RIBBLE VALLEY BOROUGH COUNCIL

please ask for: GRAEME THORPE
direct line: 01200 414520
e-mail: graeme.thorpe@ribblevalley.gov.uk
my ref: 3/2012/0401/P
your ref: APP/T2350/A/12/2184630/NWF
date: 22 NOVEMBER 2012

RE – Appeal by Phillips Property Limited against the failure of this Council to determine the application within the appropriate period. Outline planning permission is sought for the proposed re-development of land for residential purposes at 51-53 Knowsley Road, Wilpshire, Lancashire, BB1 9PN.

Drawing Title
Proposed Ground Layout

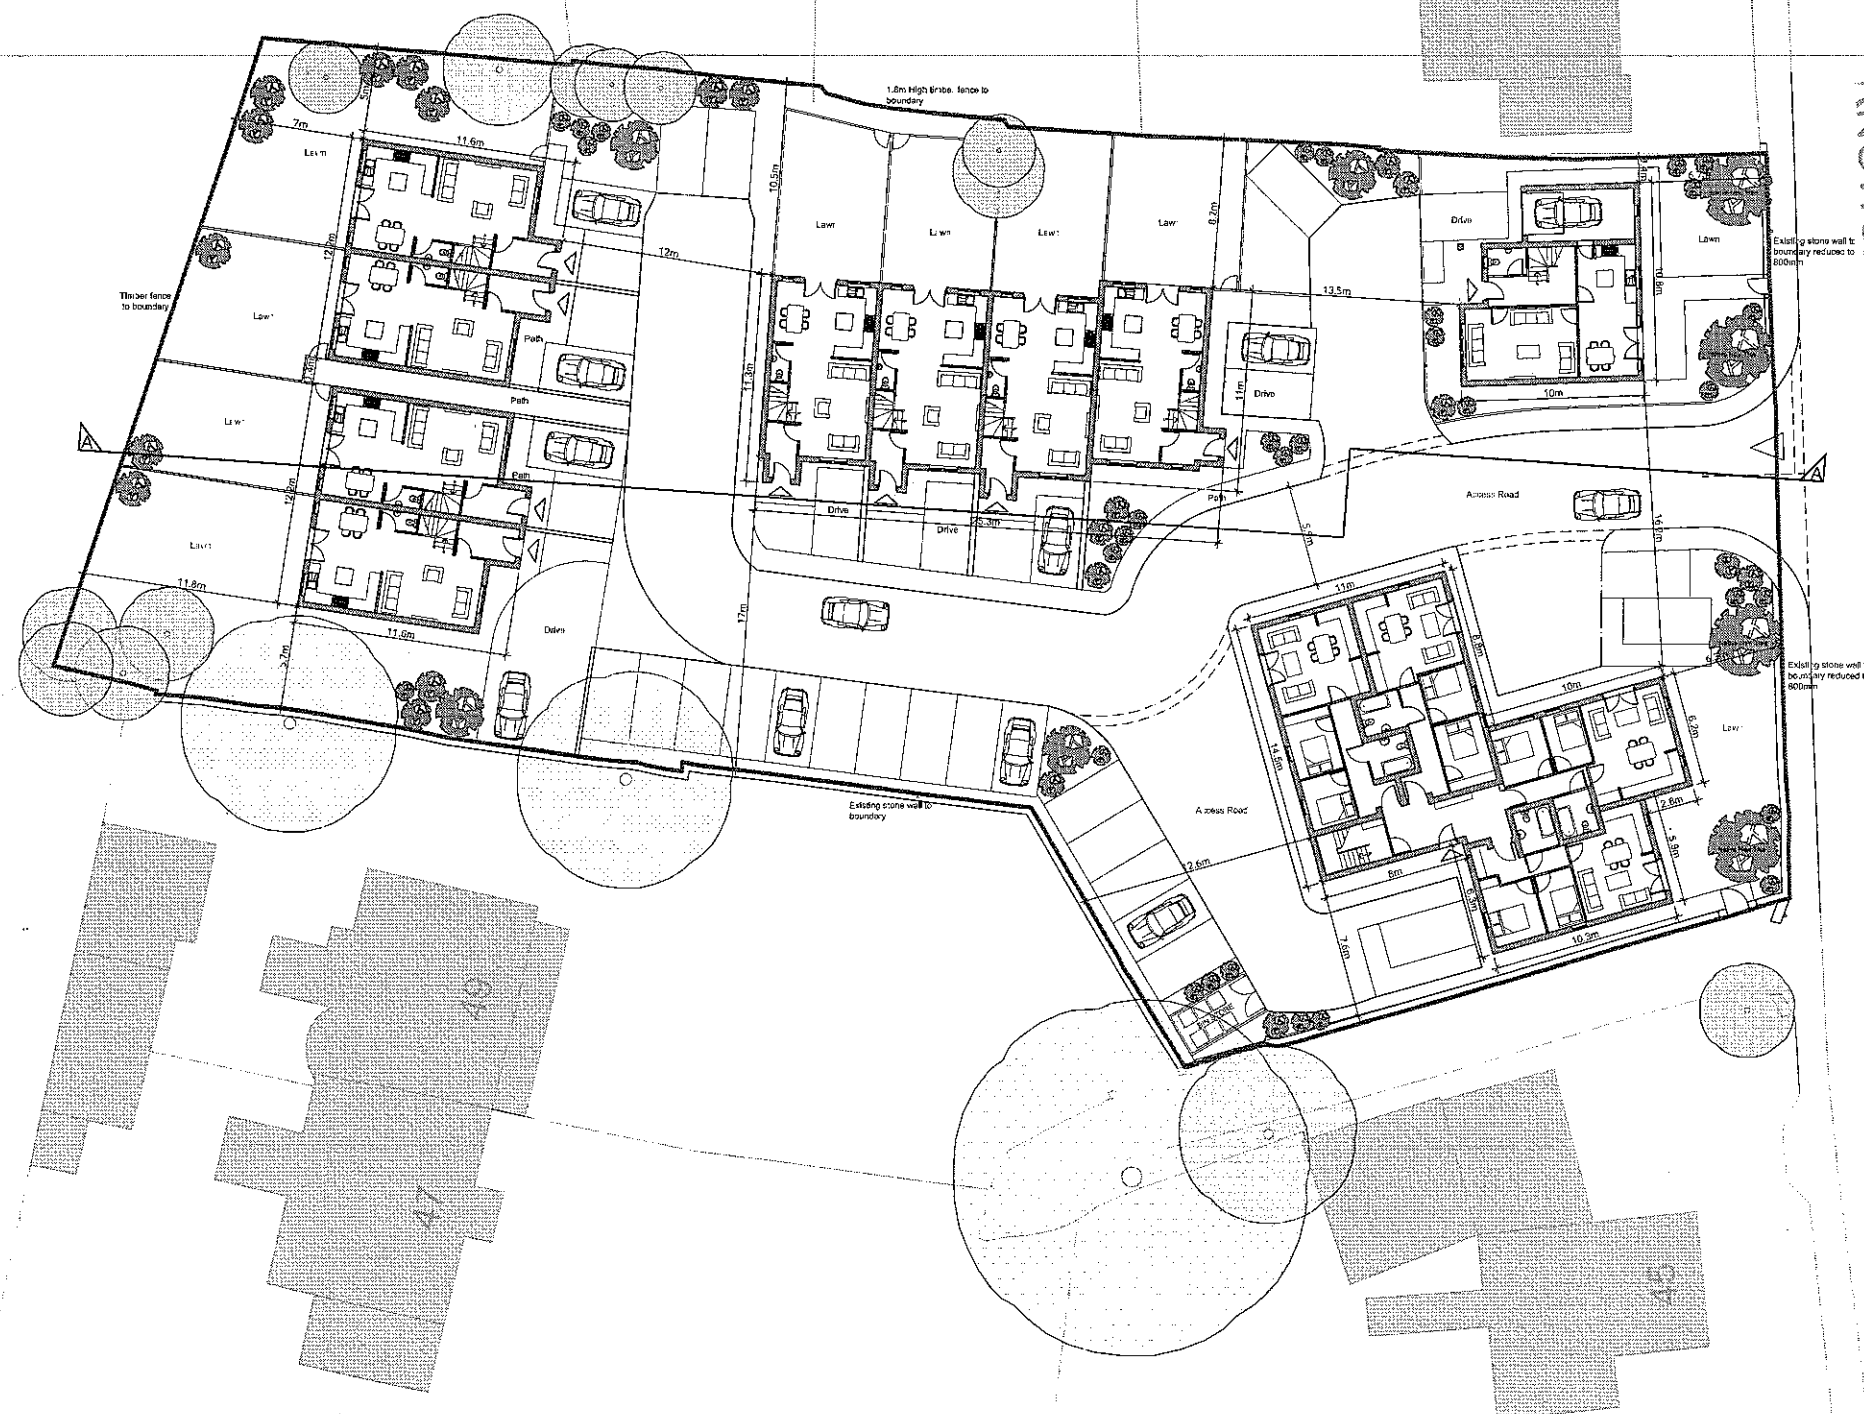
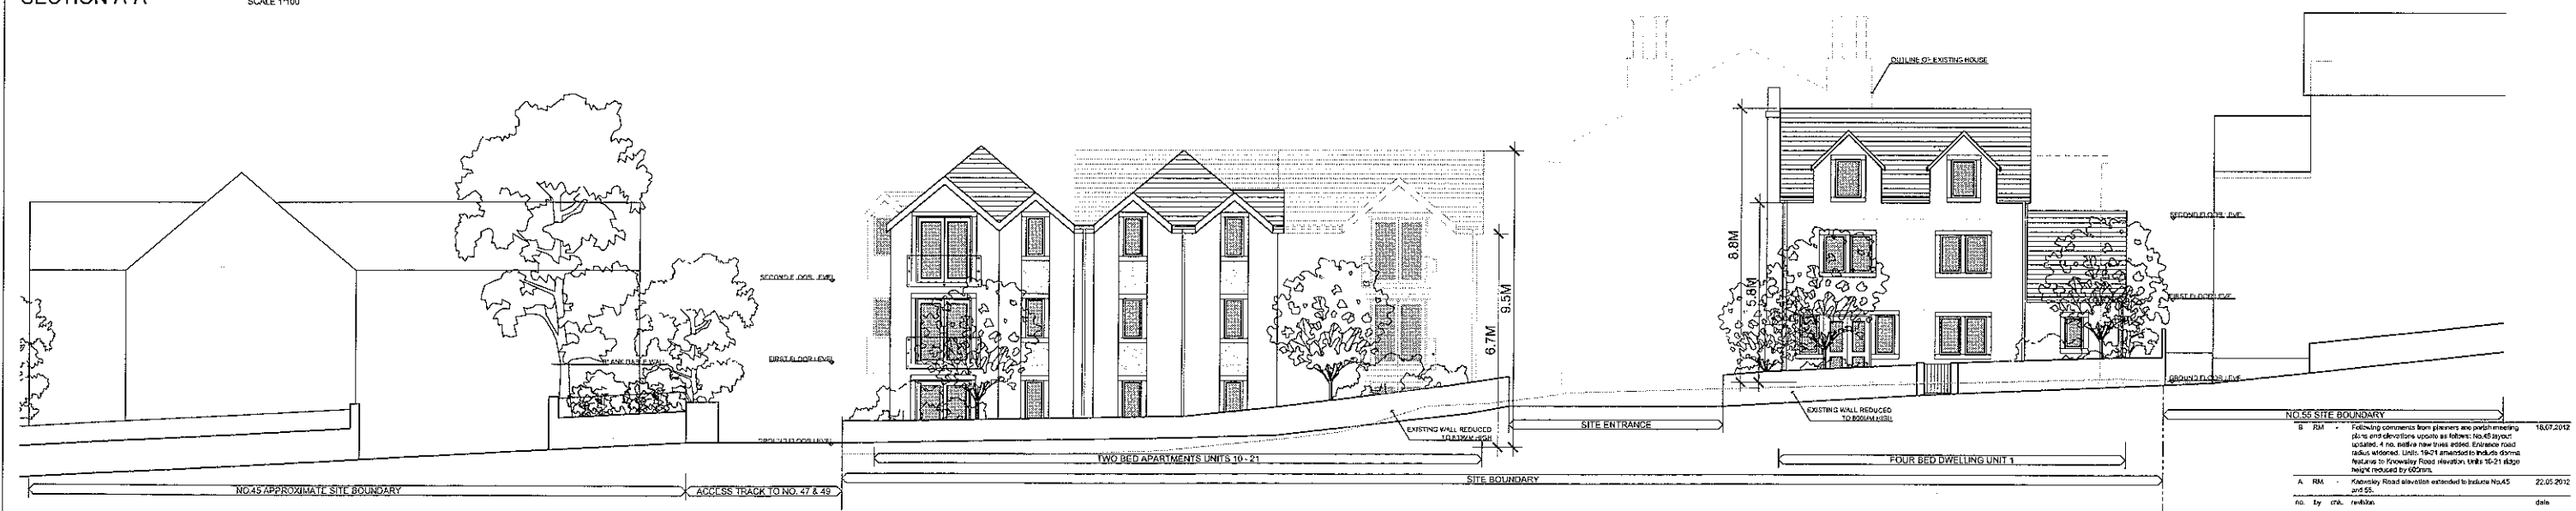
4. The harm of the overcrowded proposal is two fold as the block of terraced properties in the centre of the site and the three storey block of apartments on the Knowsley Road frontage are not considered to accord with the locality and appear misplaced and out of keeping, with their approval also leading to conditions to the detriment of the amenity of the occupiers of adjacent dwellings. The overall scale of the proposed three storey apartments is also considered excessive, and due to its more prominent location positioned directly on the street frontage of Knowsley Road, would appear dominant within the streetscene thereby impacting on the character of the street scene at this location to its visual detriment.

5. With regards to the impact on the amenity of the occupiers of adjacent dwellings, the proposed first and second storey windows within the apartments would directly overlook the front garden areas of numbers 49 and 54 Knowsley Road, which are both clearly used for enjoyment. It is appreciated that the front-facing rooms and garden at no. 54 can already be seen to some extent from the road, however it is considered that the proposed development would result an unacceptable increase in actual and perceived loss of privacy at both properties. There is also some concern regarding the potential loss of privacy to the occupier of no. 45 Knowsley Road, however this is mitigated to some extent by existing boundary planting on their land. Landscaping would not overcome the harm, as suggested by the additional planting proposed, because any planting on the boundary high enough to screen first/second floor windows would be likely to block light to those windows and would therefore prejudice the living conditions of future occupiers of the development.

6. With regard to the block of terraced properties within the centre of the site, due to their position on site, the short distance between the most easterly positioned unit

and the corner of the apartment block, the small amenity areas to the rear of the buildings and the large number of private and shared parking spaces in front of the dwellings, these units appear cramped and ill-conceived. The spacing and density on site is particularly worsened by these units in particular as they require the access road and parking spaces to be tightly positioned to the boundaries and also reducing the openness for the two pairs of units at the rear of the site. This is clearly contrary to guidance within paragraph 58 of the NPPF.

7. This cramped design and reduced rear amenity areas also means that views from the rear elevation of the row of terraces in the centre of the site will have an unacceptable impact upon the occupiers of properties to the north, numbers 55 and 57. Recent appeal decisions have supported the Council's concern for developments causing a loss of privacy and in this case given the distance of 8.2m between the rear elevation of the most easterly positioned end terrace unit and the northern boundary of the site that borders the rear gardens of no. 55 and 57 Knowsley Road. It is considered that any rear facing bedroom windows in the proposed house would afford views into rear garden area of this property, with the potential also for views into habitable rooms, despite the orientation, leaving the occupiers with a strong sense of intrusion.
